Planning Application Ref: A/70/18/DOC

Location: Quiet Waters, Roundstone Lane, Angmering

Description of works: Application for approval of details reserved by condition imposed under planning permission A/132/17/OUT relating to condition No. 17 (Tree scheme of protection) & 22 (Contamination risks)

Scale: 1:250@A1	Drawn: AR	Date: 05-01-17
Drawing Number: RCO 193 / 01	Revision: 02

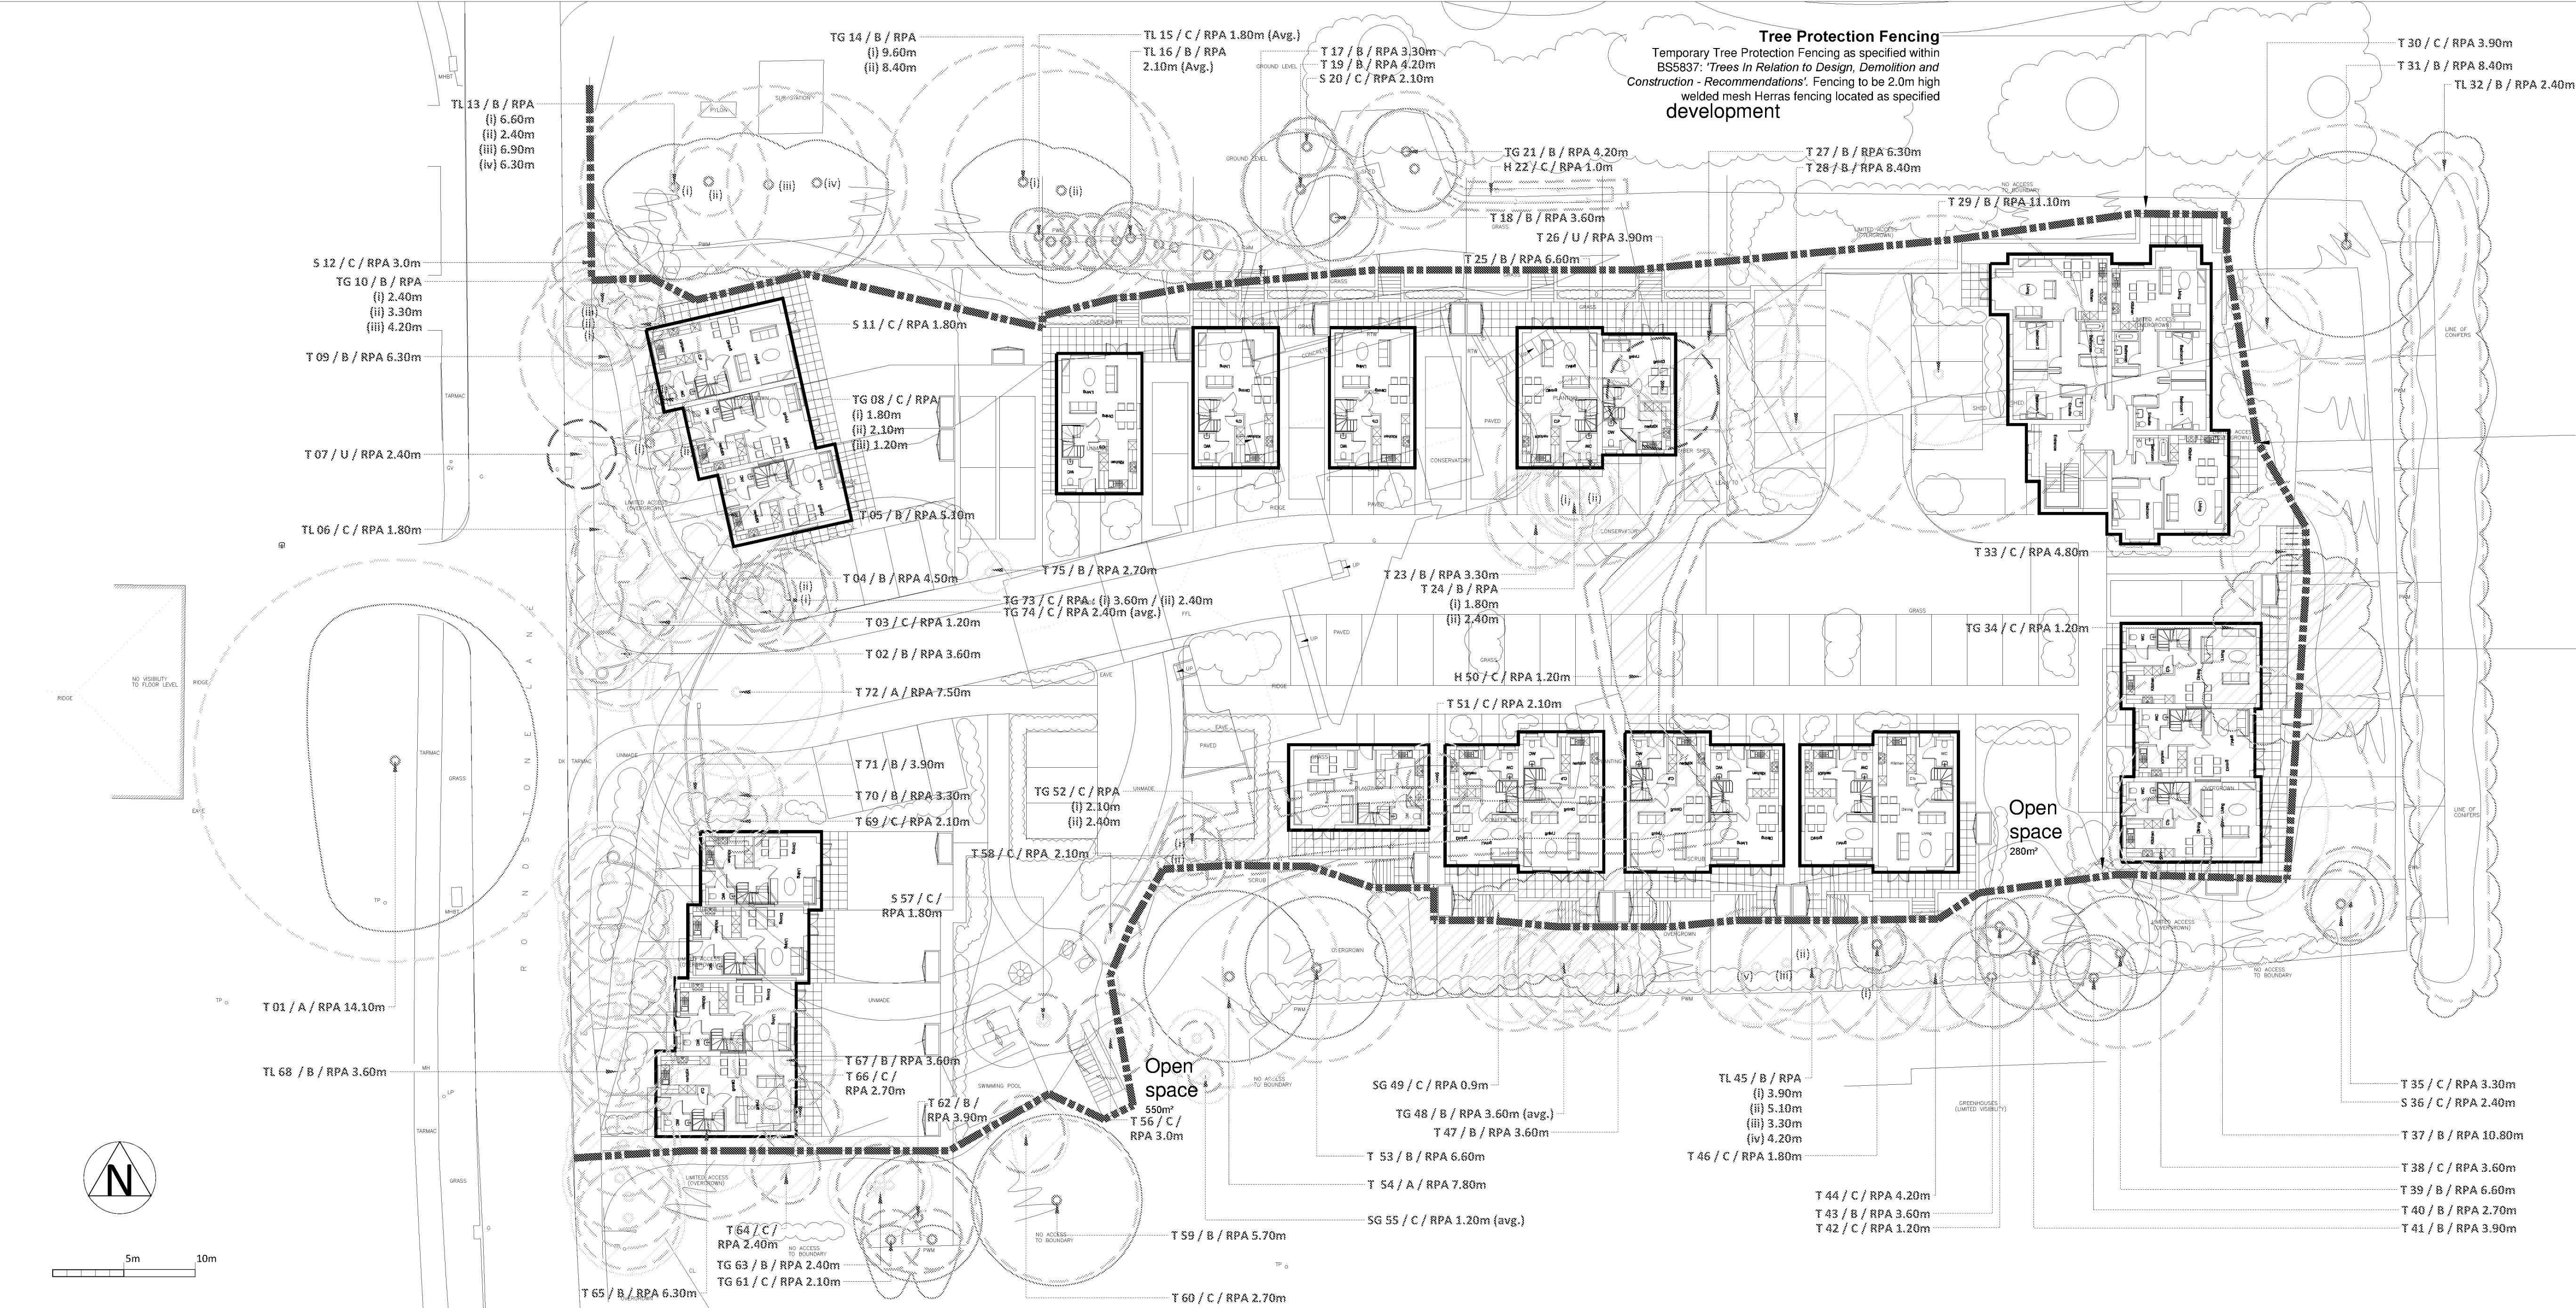
- Drawing No. NJCL 252 C, dated 21.05.2018, from Nicholas Jones Consultants Ltd., submitted in support of A/81/18/RES
 - Drawing No. RCo 193/01 (Rev:02), dated 05.01.2017, from Ramsay & Co Landscape Architecture, submitted in support of A/132/17/OUT

- Both plans appear to specify 'fit for purpose' fencing in similar if not identical position, to effectively form a construction exclusion zone around significant retained trees, as is standard practice and required by BS5837.

- None of the aforementioned fencing has been installed or even brought to site at this time. I attach photographs taken at the time of my inspection.
- Deep excavation has recently been undertaken in connection with underground utility apparatus immediately inside the main site entrance. This does not interfere with the root protection area of trees proposed for long-term retention.

- The developer must now install permanent fencing in accordance with their most Tree Protection Plan and as a matter of urgency; to form effective Construction Exclusion Zones so as to adequately respect and protect significant trees on site before any further work occurs.
- As things stand, I am unable to recommend 'signing off' on this part of Condition 17.
